Our Ref: FP/202/19/PL

**Town & Country Planning Act 1990 (as amended)
Town and Country Planning (Development Management Procedure) (England) Order 2015
Application for Planning Permission**

Development Change of use from launterette (Sui Generis) to shop (A1 Shop) (resubmission following FP/132/19/PL).

Location Grassmere Parade, Shop 3 Felpham Road Felpham

DRAWING TITLE:
EXISTING & PROPOSED ELEVATIONS & FLOOR PLAN
PROJECT:
CHANGE OF USE FROM SUI GENERIS TO A1

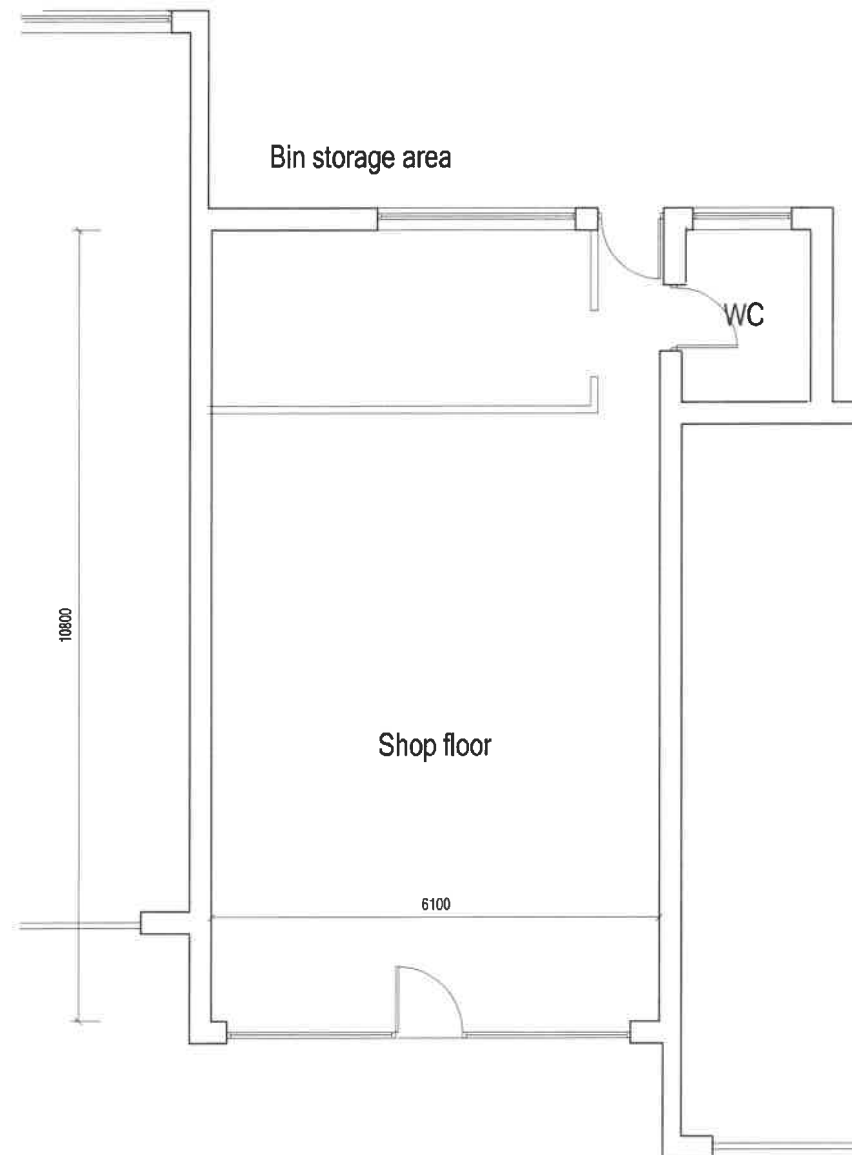
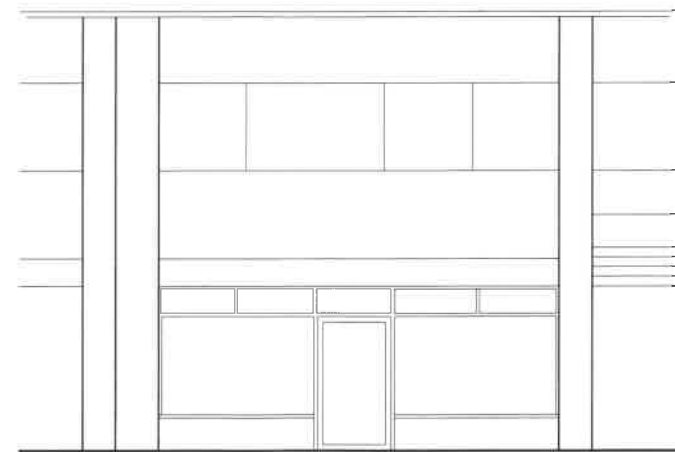
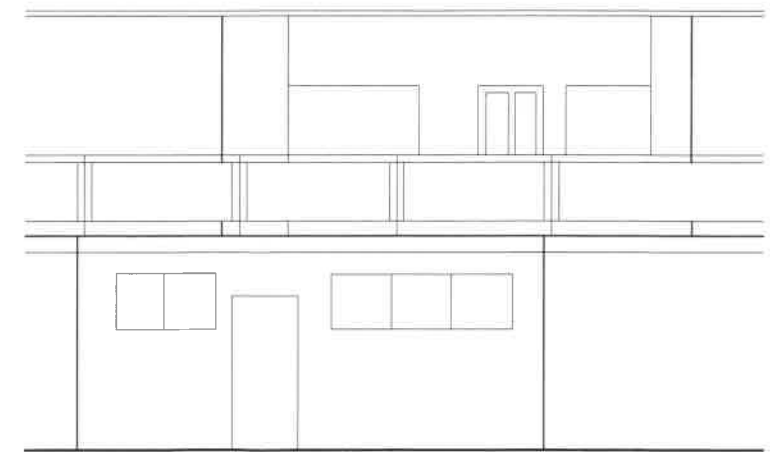
Please submit 1 electronic or 3 paper copies of clearly labelled existing and proposed floor plans at a scale of 1:50 or 1:100. Further details can be found in the National Validation Requirements.

Please submit 1 electronic or 3 paper copies of clearly labelled existing and proposed elevations at a scale of 1:50 or 1:100. Further details can be found in the National Validation Requirements.

This application requires the provision of bin storage/collection facilities. Please provide details in the format as set out in the Local Validation Requirements so that Environmental Services are able to assess whether the proposal is acceptable.
